From: Simon Davis <Simon.Davis@arun.gov.uk>
Sent: 26 August 2021 15:55
To: Planning.Responses <Planning.Responses@arun.gov.uk>
Subject: Ref Y/97/21/DOC

Further Conservation Officer comments

From: Martyn White <Martyn.White@arun.gov.uk> **On Behalf Of** Conservation Officer
Sent: 25 August 2021 16:45
To: Simon Davis <Simon.Davis@arun.gov.uk>
Subject: RE: Condition 5 of planning ref. Y/63/19/RES

Amended/further details received in respect of condition 5: *"No development above damp proof course (DPC) level shall take place unless and until details of the construction and materials of all front openings, windows and doors for plots 2-7, 19-21 & 36-41 and the front & right hand side openings, windows & doors for plot 1 have been submitted to and approved by the Local Planning Authority and the new windows and doors as approved shall then be constructed in accordance with approved details. The submitted details shall include the style and material of the window frames, the arrangement of glazing bars, the set-back of the frames from the external wall face and the window sills."*

Typical detail
Window head sill and jamb
in brick elevation

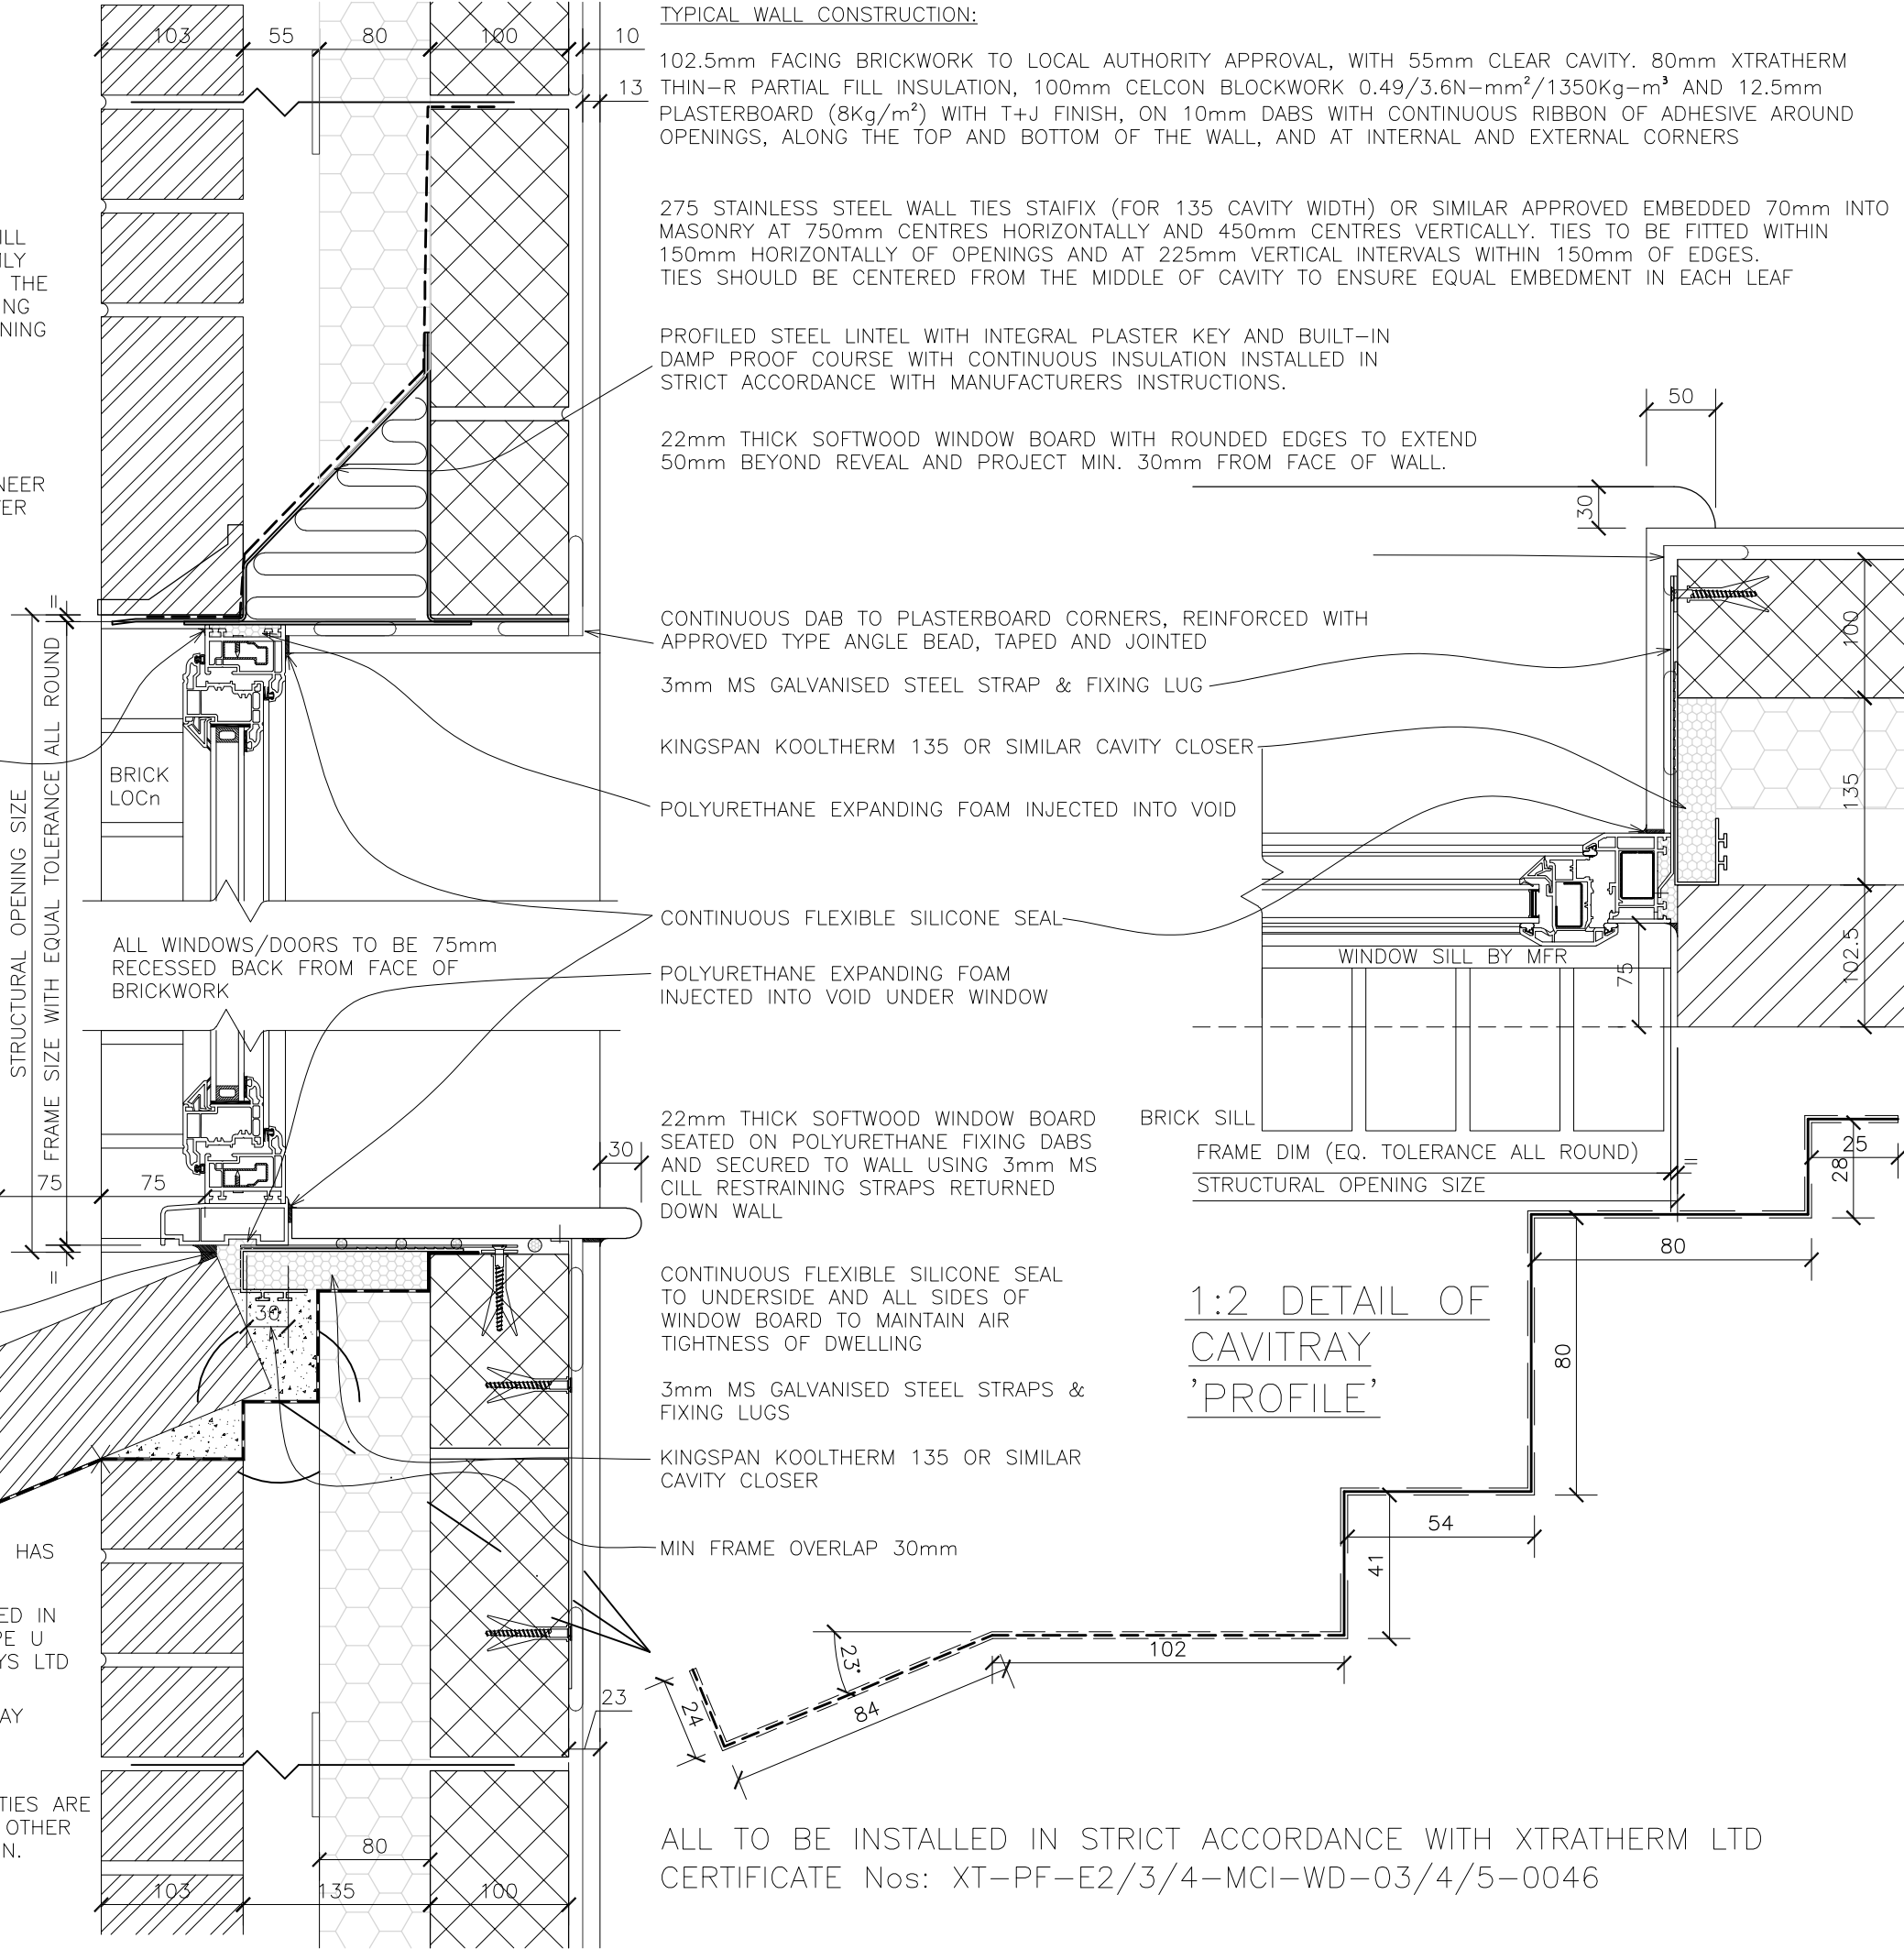
I have looked at the information for the windows and think that they look to be fine. I am assuming that they will be installed as per the previous plan i.e. recessed so as to create the shadow line.
